# CITY OF ALBUQUERQUE

**RE: Nuevo Atrisco  
7909 Central Ave. NW  
Permanent C.O. - Denied  
Engineer's Certification Date: 9/4/20  
Engineer's Stamp Date: 12/3/19  
Hydrology File: K10D058**

Based on a site visit on 9/11/20, this certification cannot be approved until the following issues are addressed:

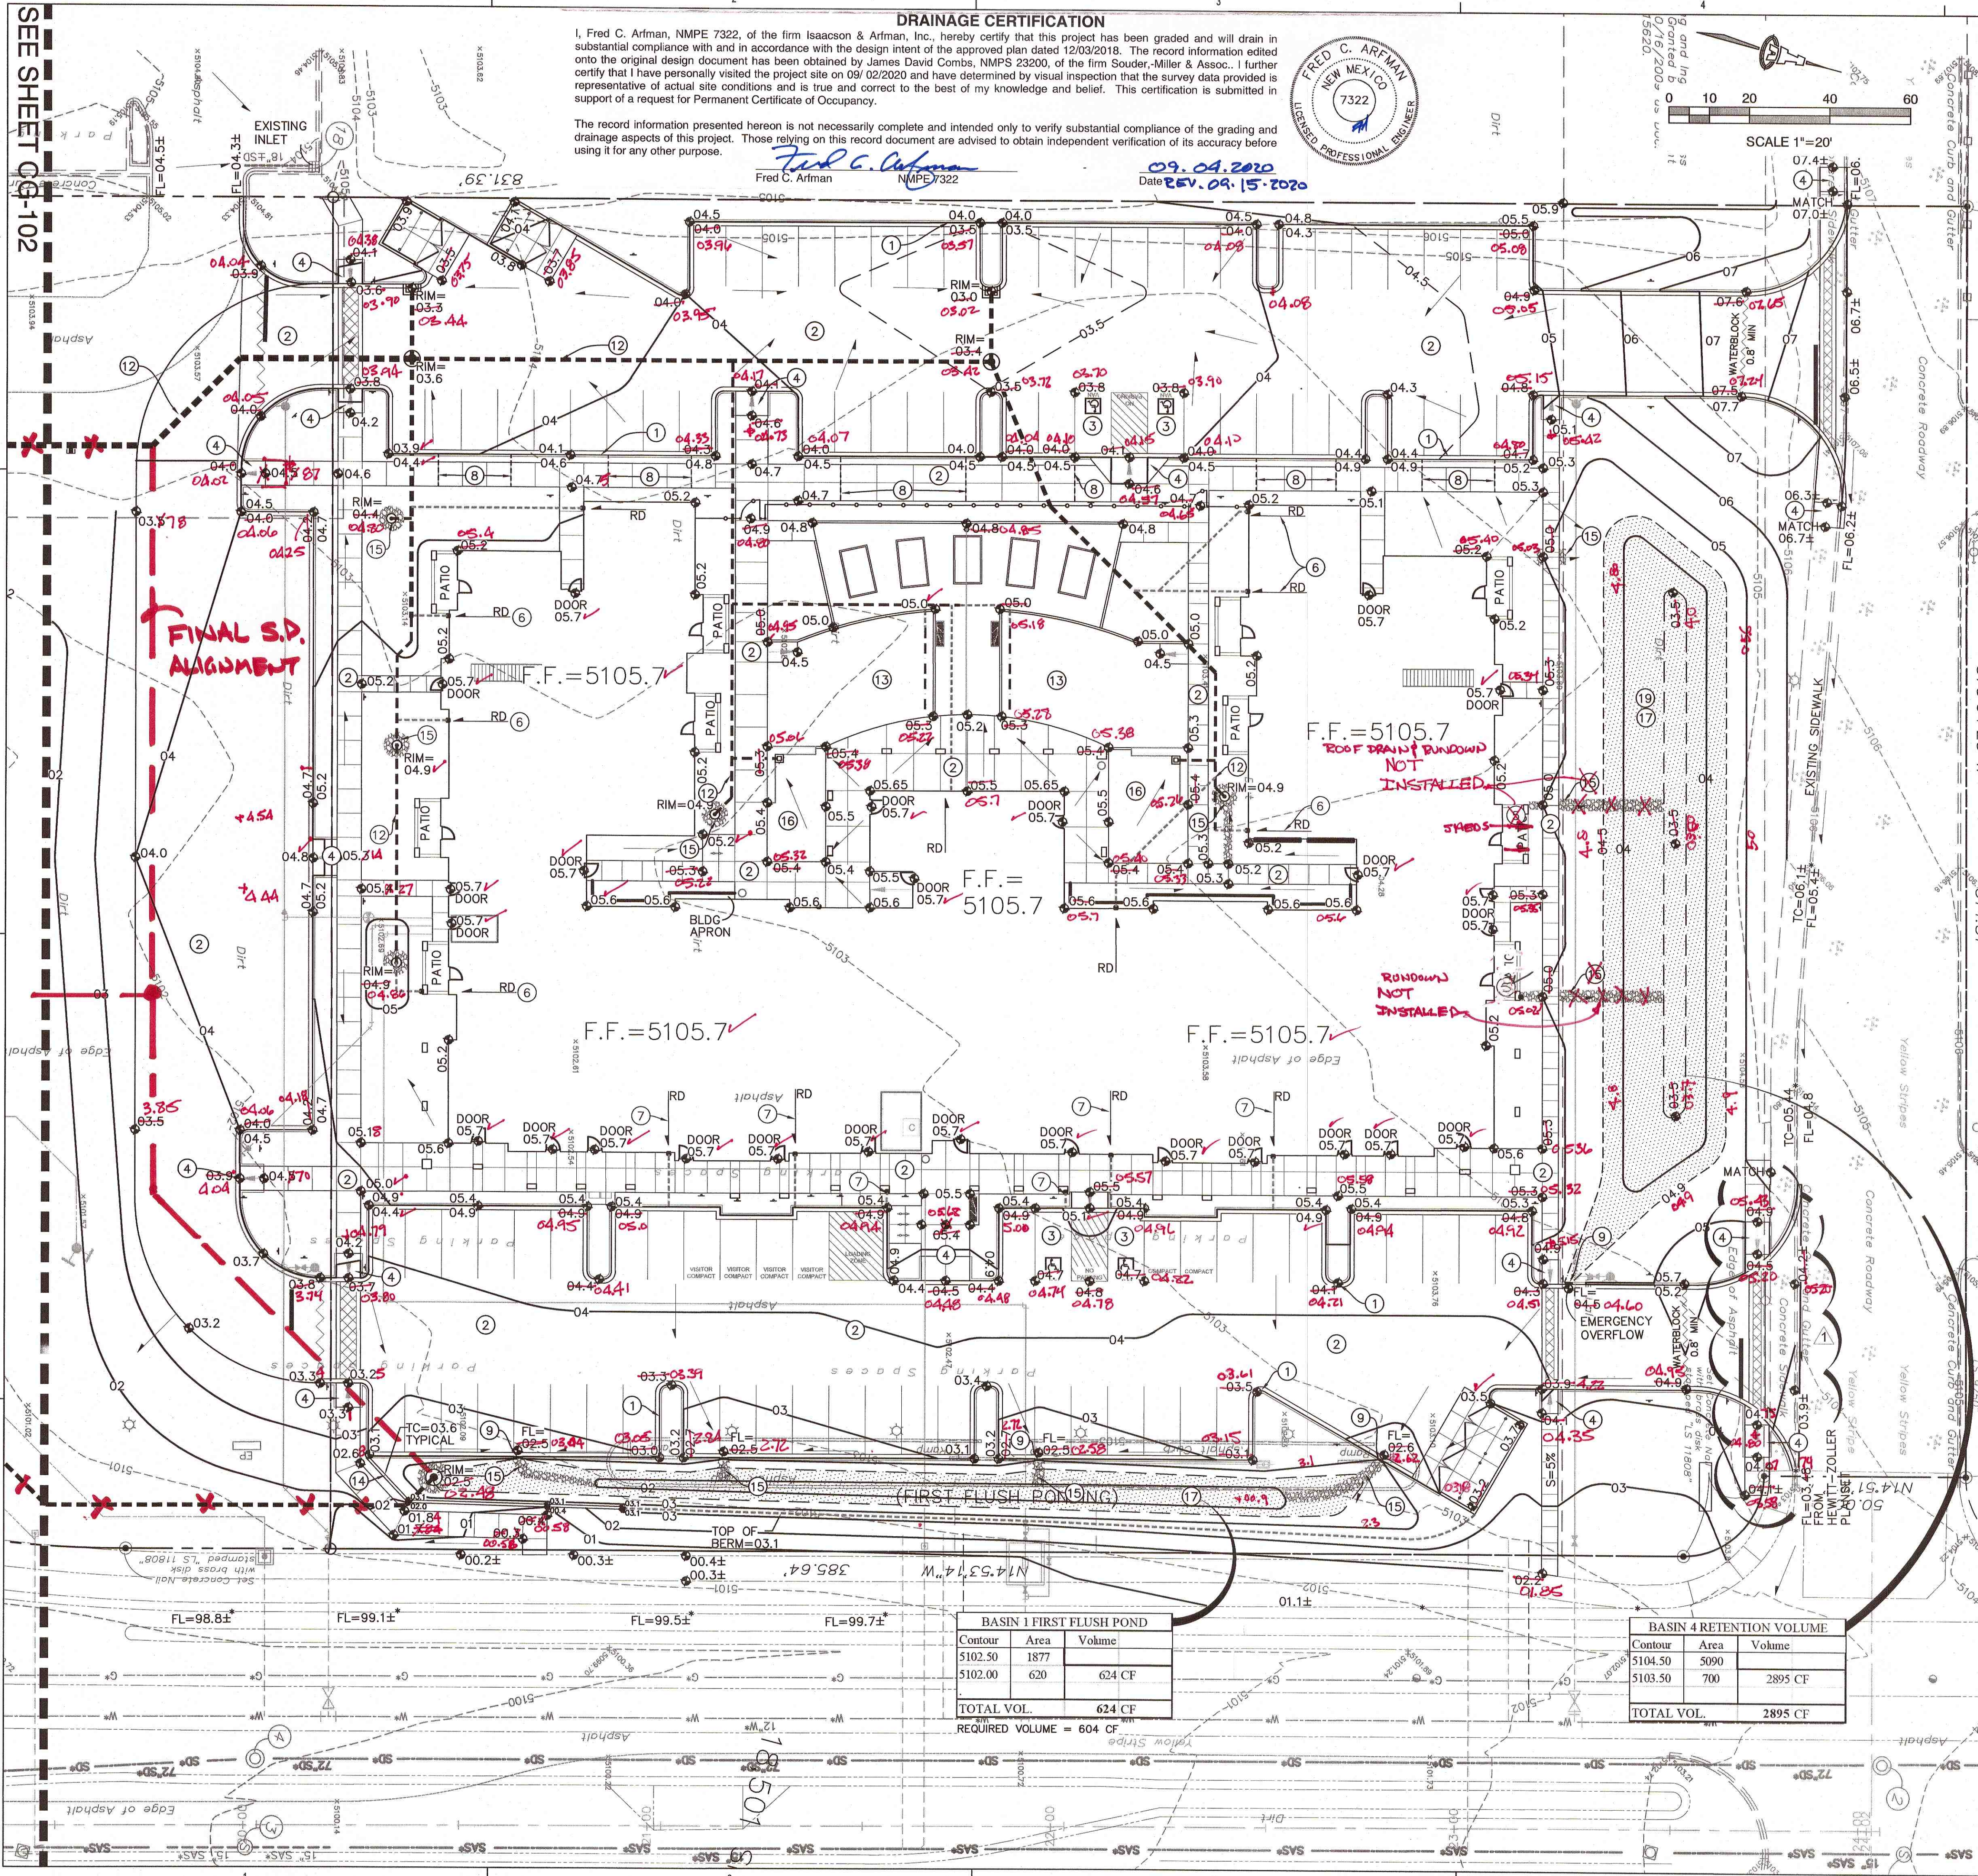
1. The building roof discharge points per keyed note 5 on the north side of the building were not evident.
2. The erosion control and rundowns from these roof discharge points on the north to the pond on the north side of the site were not in place.
